From: Claire Booth
Sent: 13 February 2014 12:34
To: Jane Tucker
Subject: FW: app3/2014/0055 Leagram Hall Chipping - Highway Response

From: Bloomer, David [mailto:David.Bloomer@lancashire.gov.uk]
Sent: 13 February 2014 11:44
To: Claire Booth
Cc: ENV LHS Customer Service
Subject: app3/2014/0055 Leagram Hall Chipping

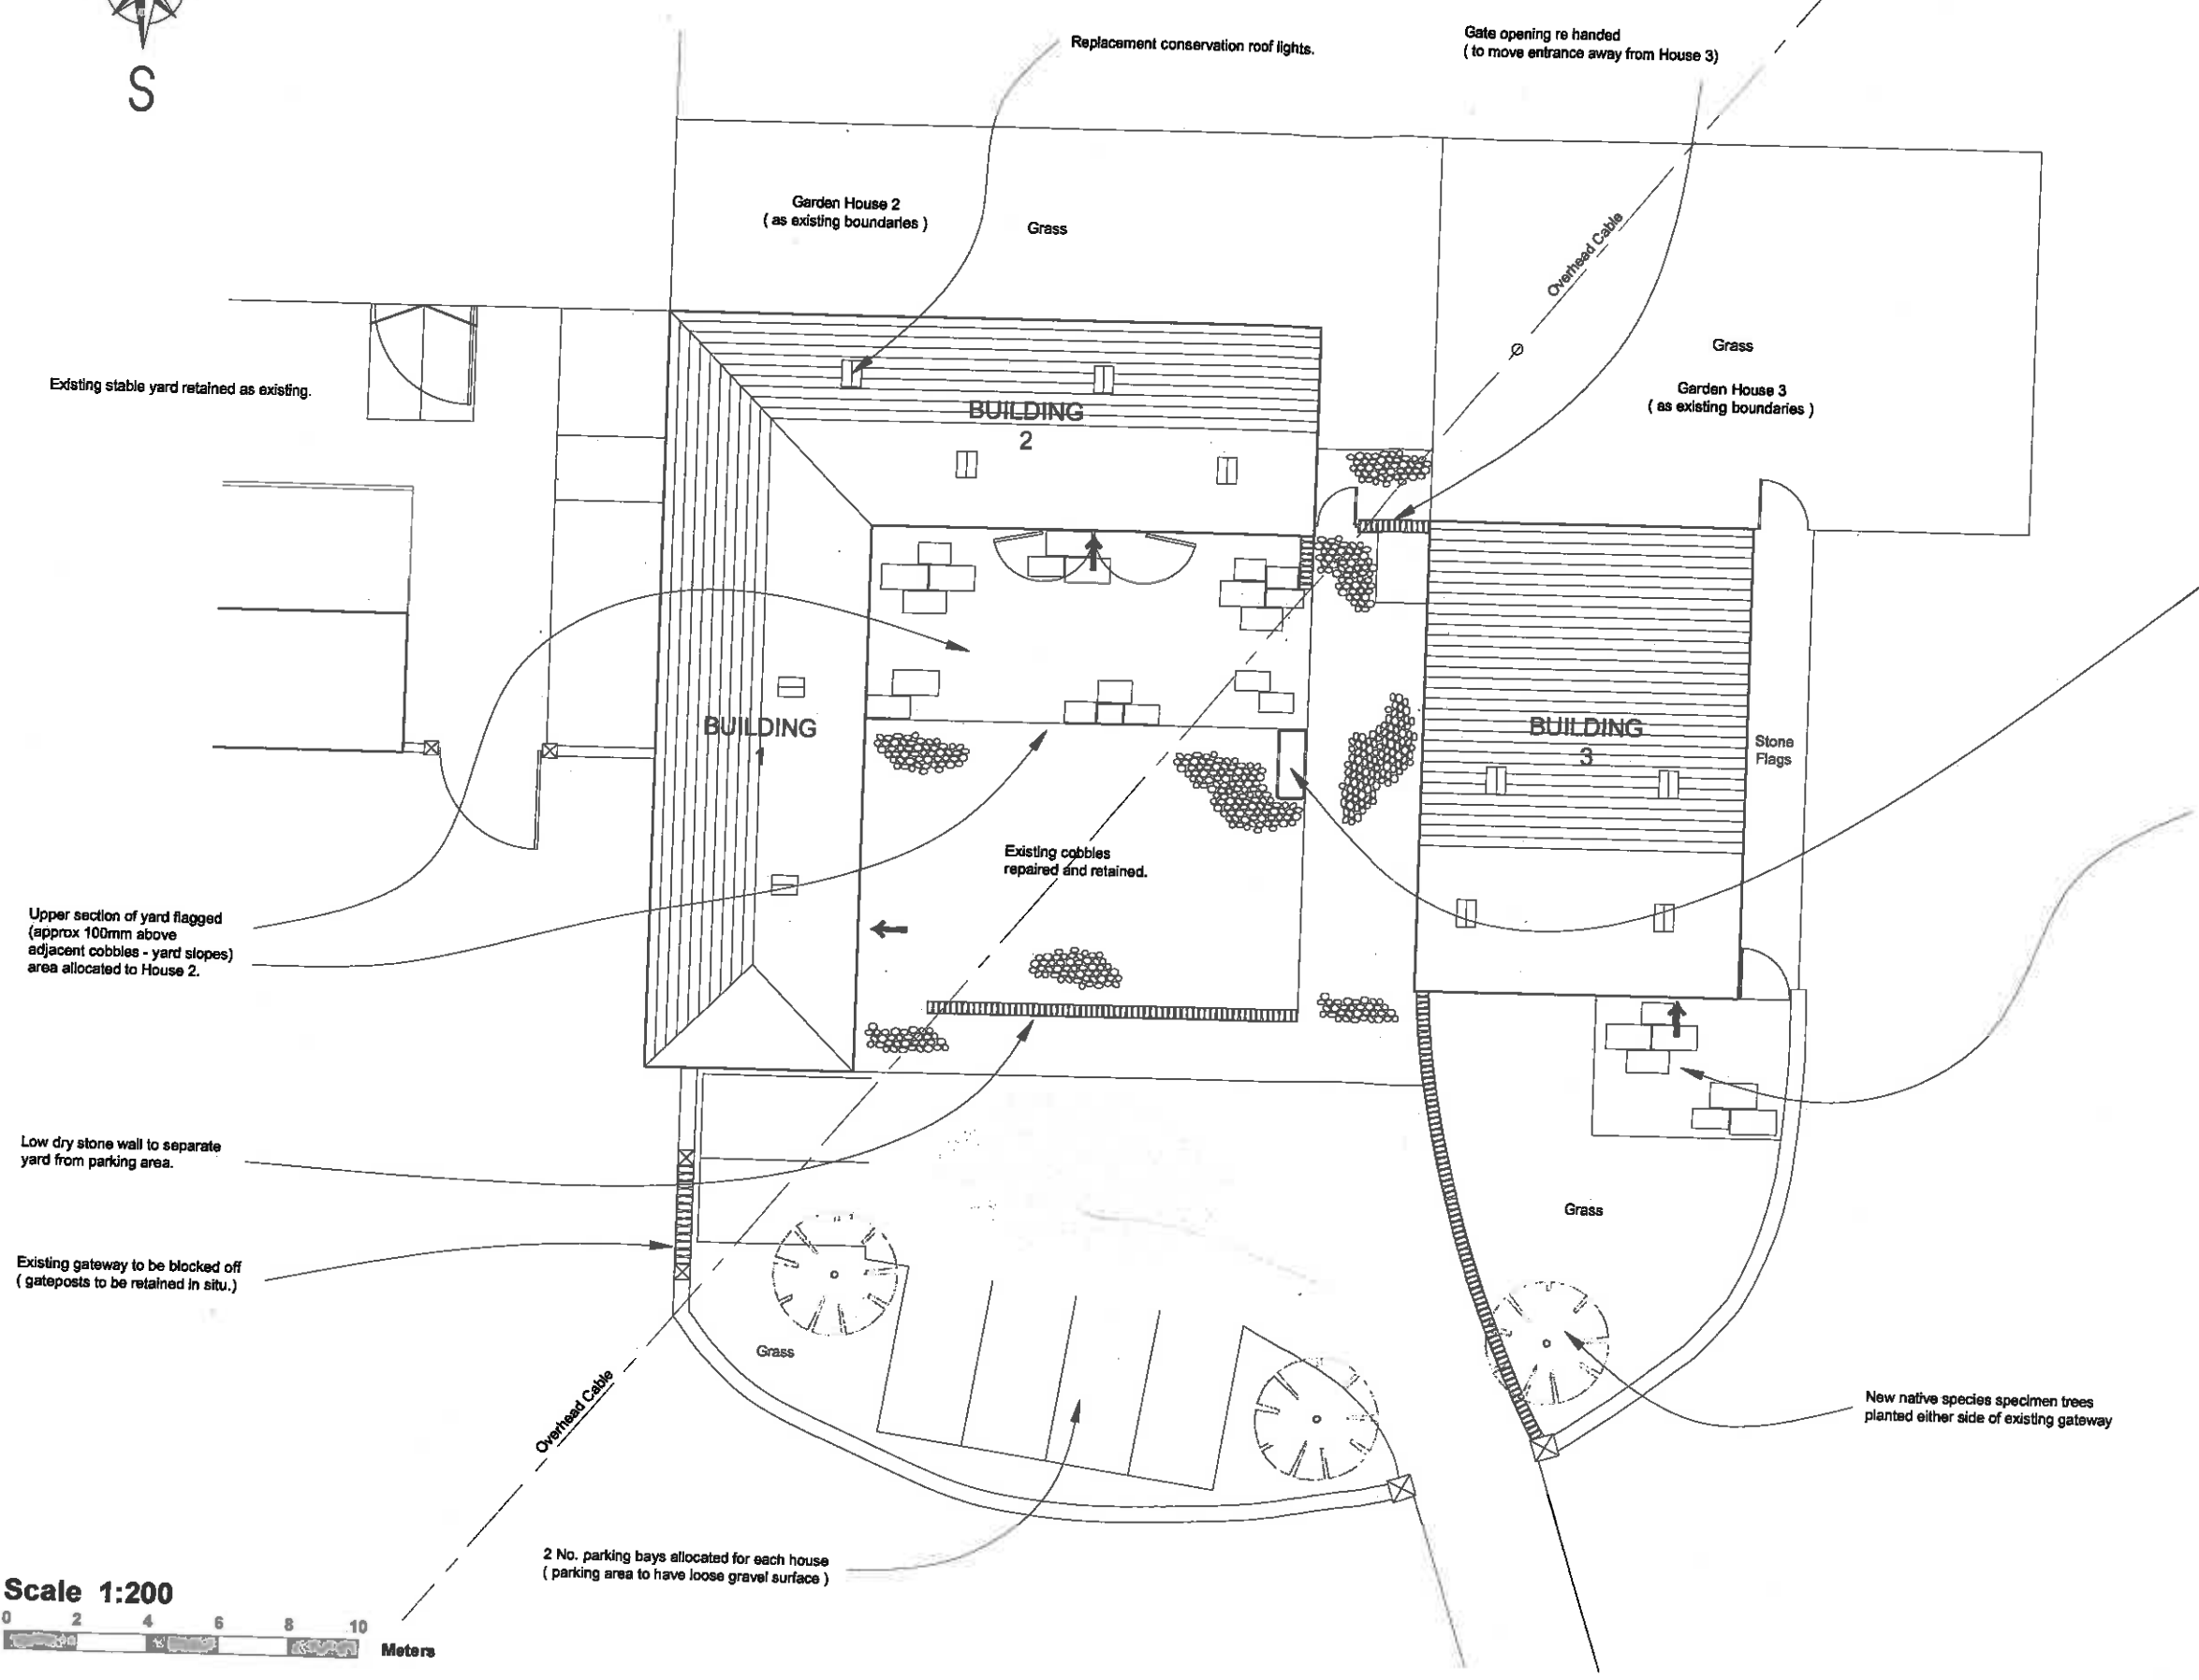
Also, whilst not a highway issue, the site plan refers to the provision of 2 parking spaces per dwelling although the plan only shows 4 spaces provided.
